Please ask for: Ms Iqraa Malik
Email: iqraa.malik@terraquest.co.uk
Telephone: 0121 234 1390
Our Ref: Y/62/22/HH
Your Ref:
Date: 12th May 2022

Application for Planning Permission for Works or Extension to a Dwelling

Development: Erection of detached single storey annexe in rear garden
Location: 27 Goodhew Close Yapton BN18 0JA

Proposed Block Plan

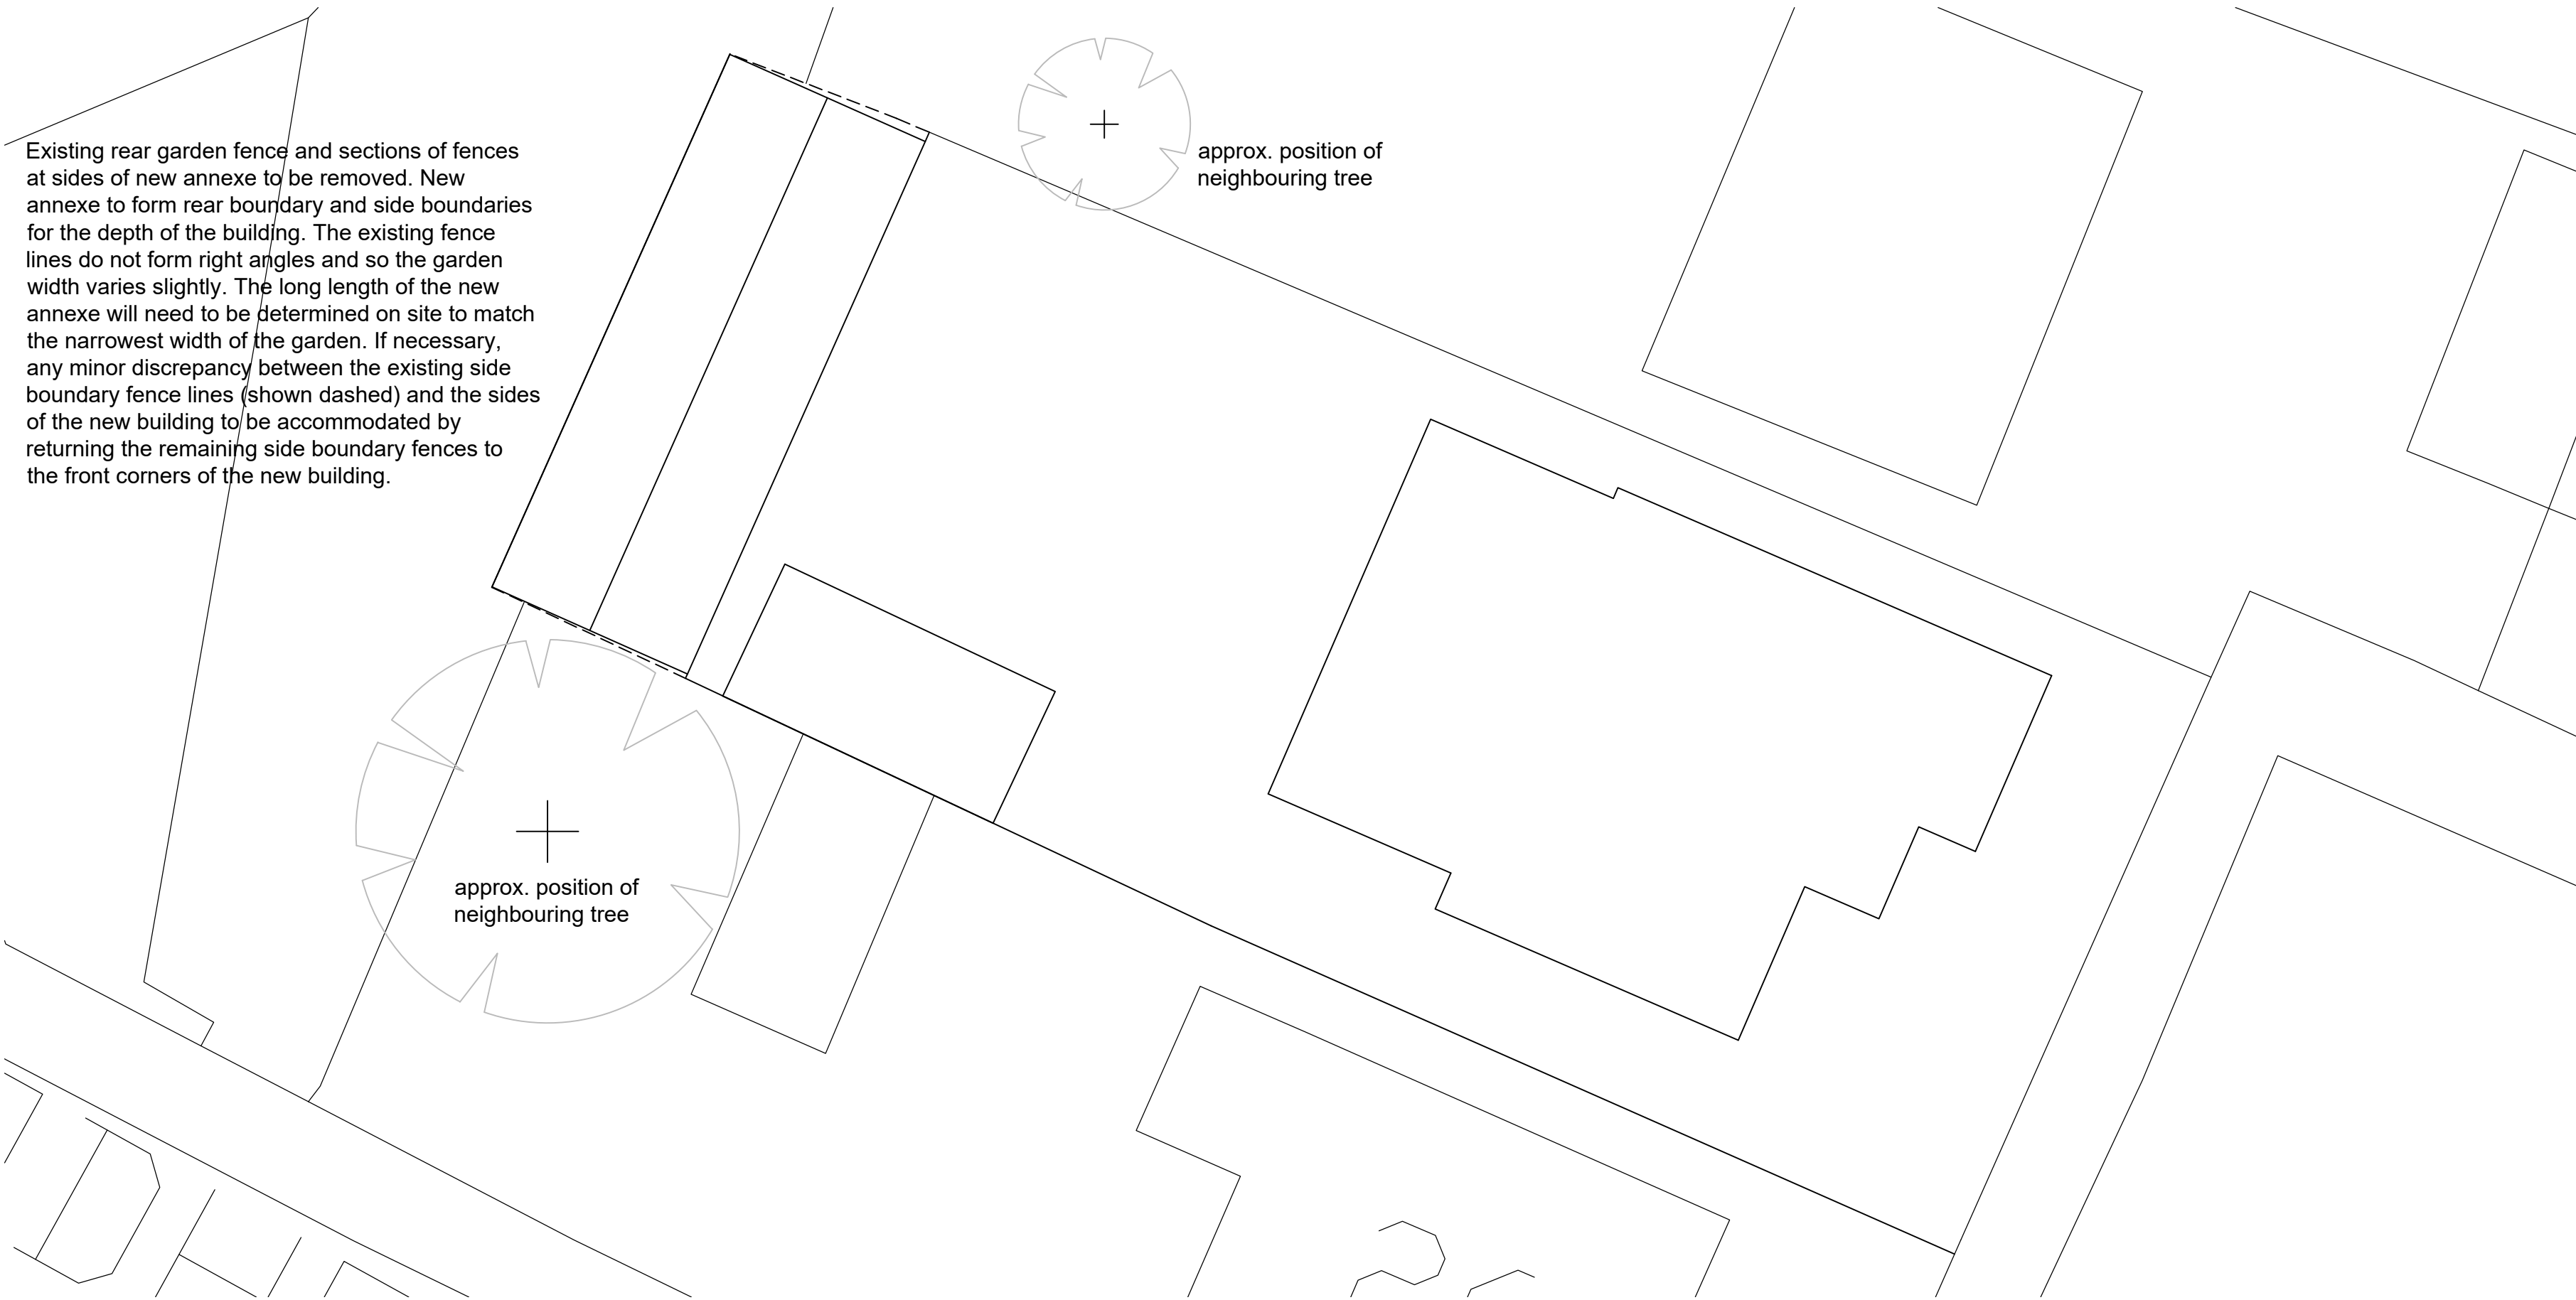
Block Plan

You are required to have dimensions from the proposed extension(s) to all site boundaries. Please amend.
